AB/107/20/L

63 High Street Arundel BN18 9AJ

Listed building consent for alterations to previously approved rear windows

PHOTOGRAPHS

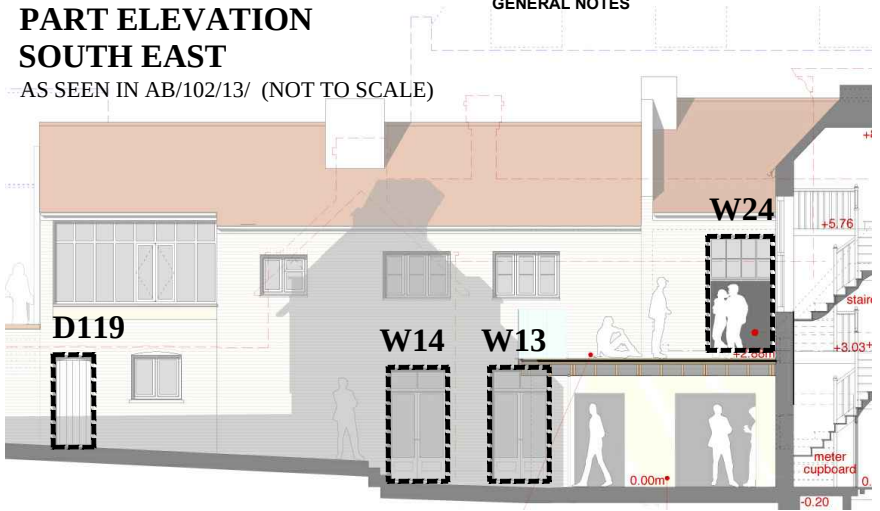
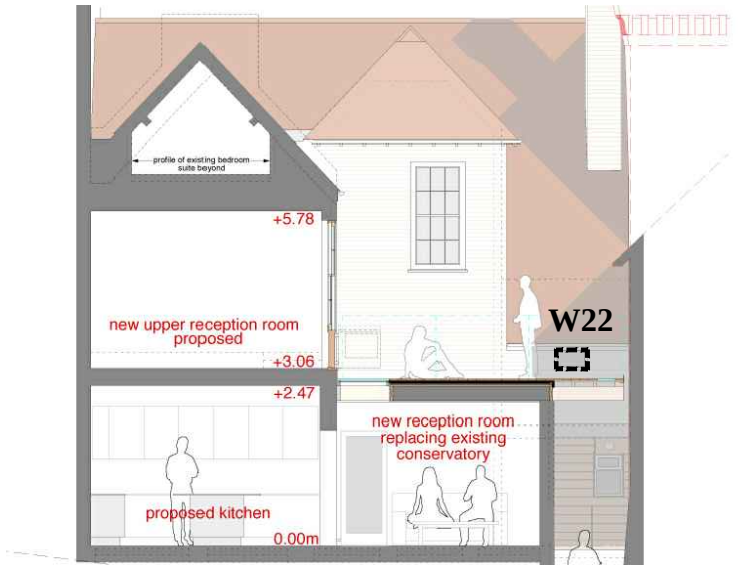
The current proposal seeks consent to vary the design/appearance of a number of windows from a previously approved scheme from 2013. I have reviewed the information supplied and considered that the amendments to the windows are such that they generally reflect the age and character of the building. Further, the location of the windows at the rear of the building is such that they do not detract from the character of the conservation area, and it is noted that the applicant states that window no. 24 was beyond repair.
